LOT 1 ACADEMY GATEWAY SUBDIVISION FILING NO. 1

DEVELOPMENT PLAN
7-ELEVEN
GRADING PLAN

PROJECT NO:	7E1024.01
DESIGNED BY:	SPM
DRAWN BY:	LER
DATE:	12/04/17
C2.0	
SHEET 3 OF 16

EROSION CONTROL PLAN

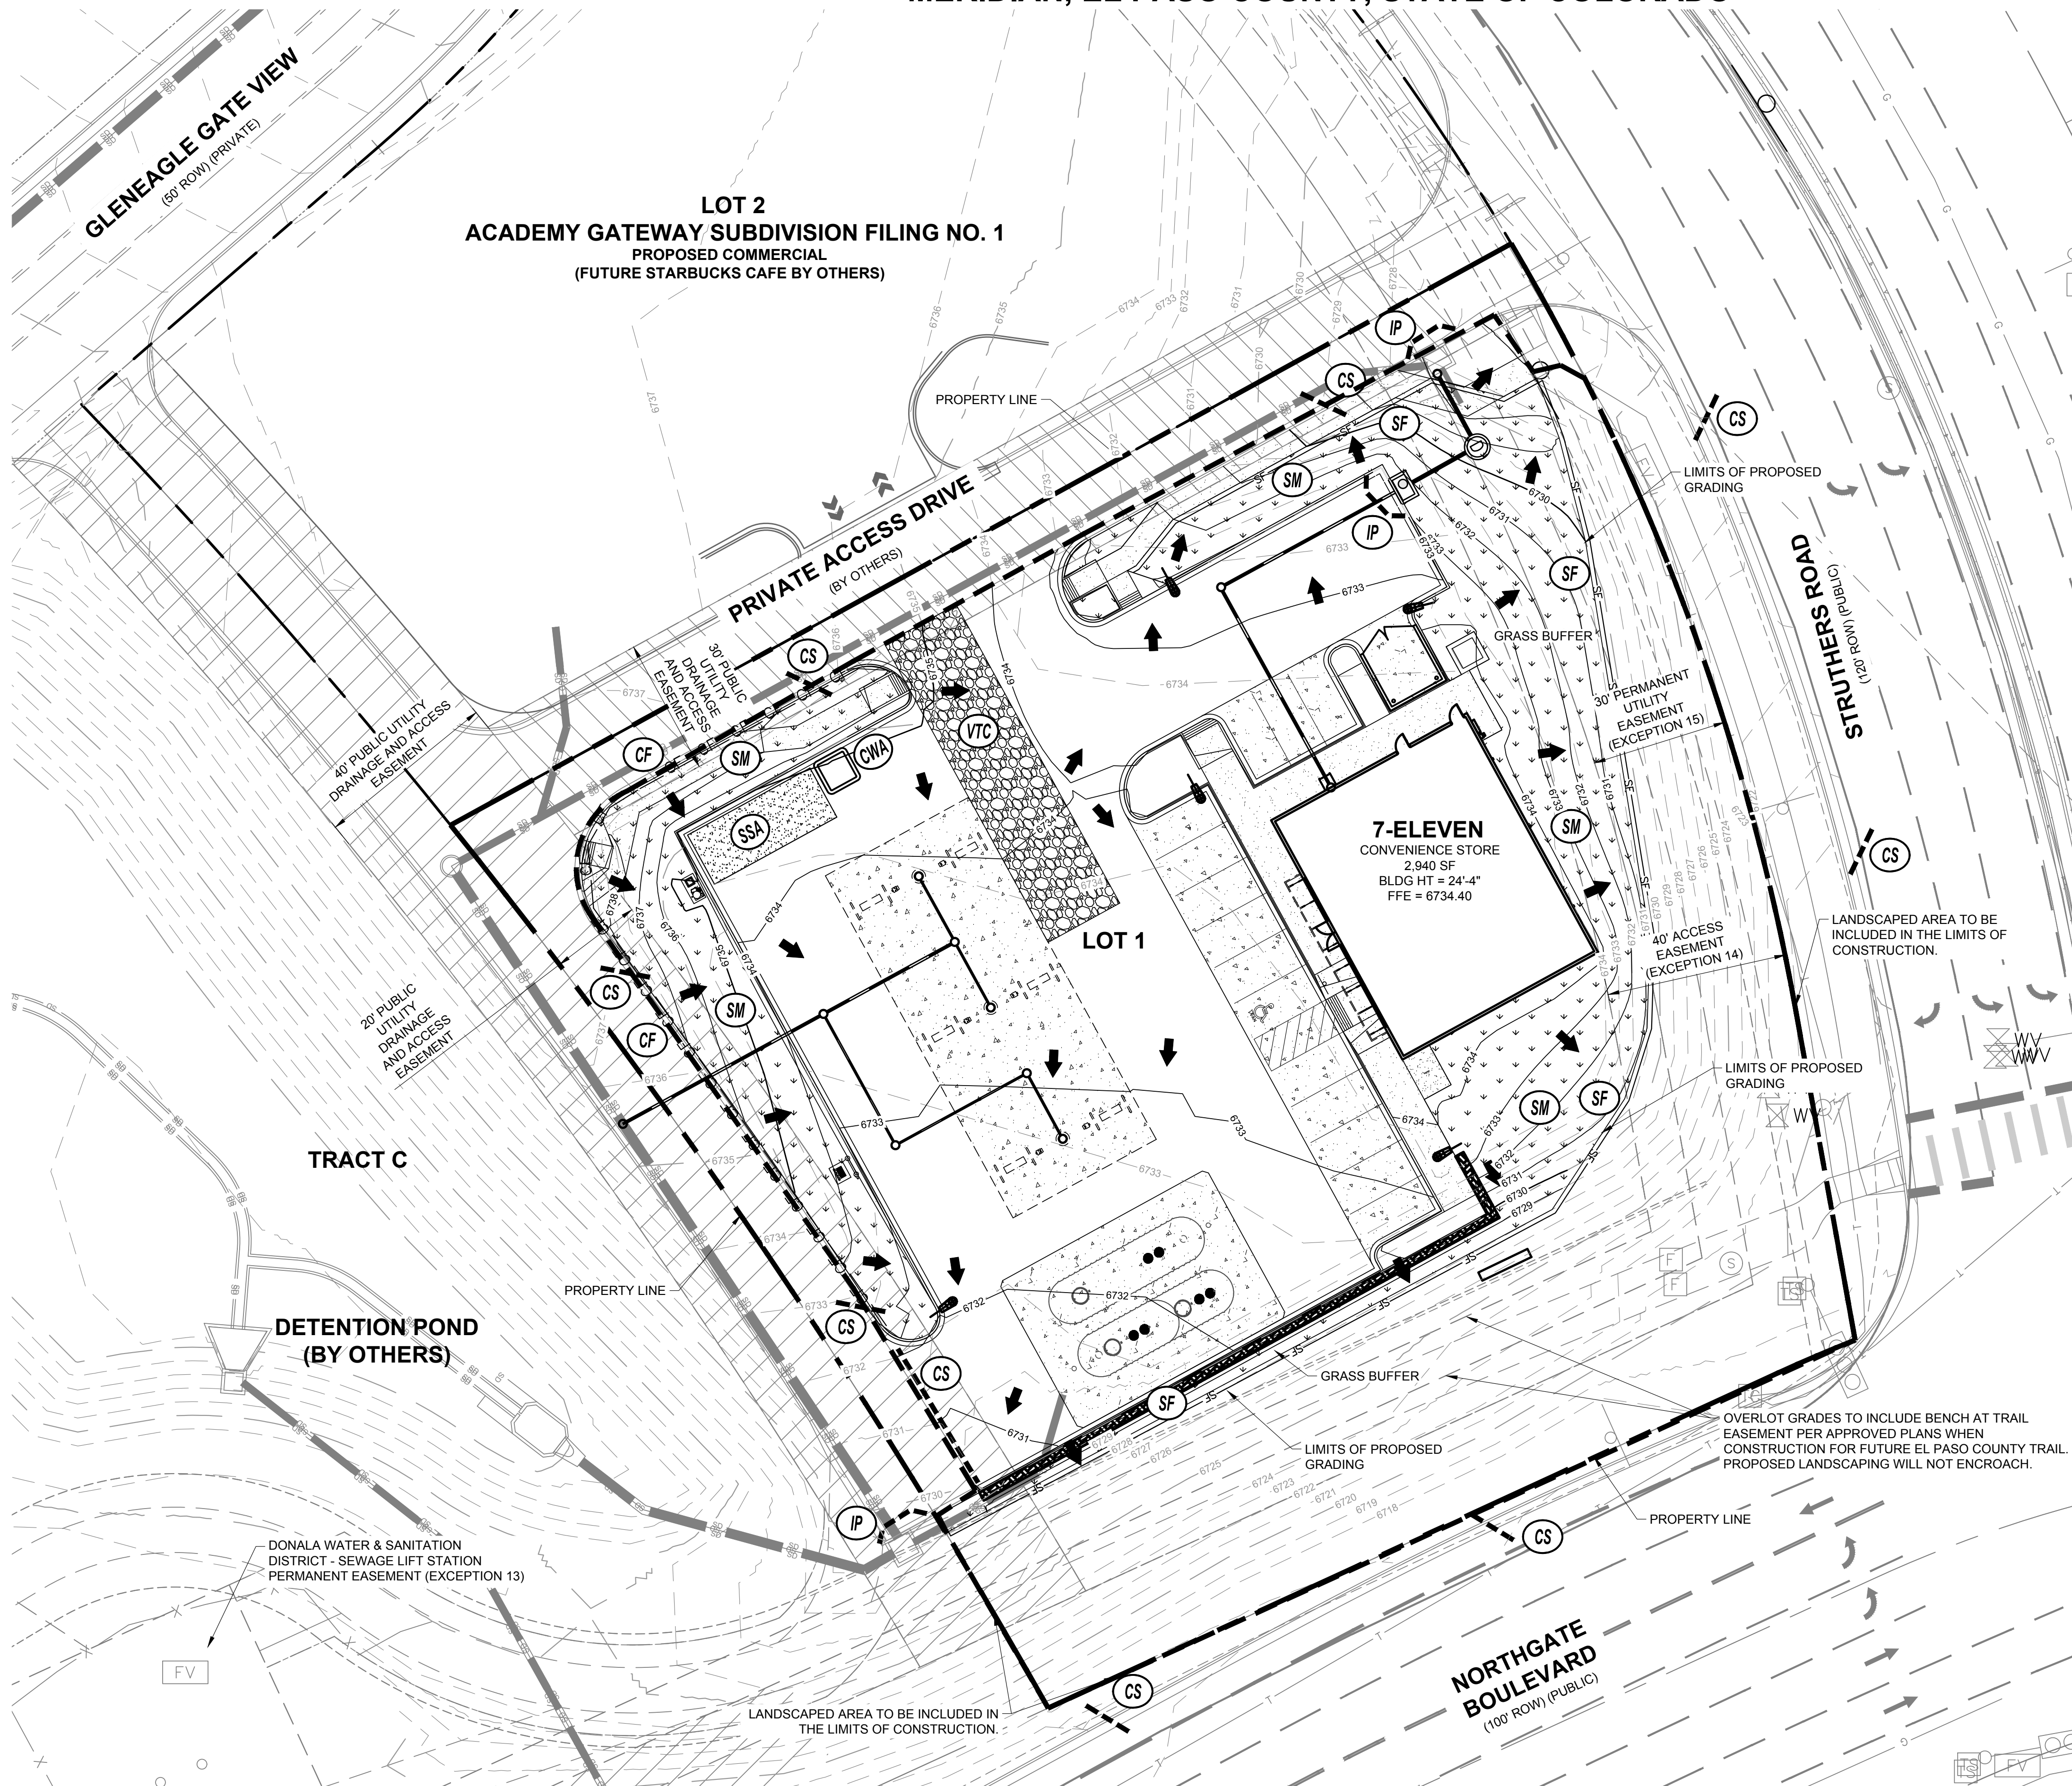
Label proposed cover of trail area.

Include all landscaped areas. Reference Landscaping Plan.

Add CS, IP...
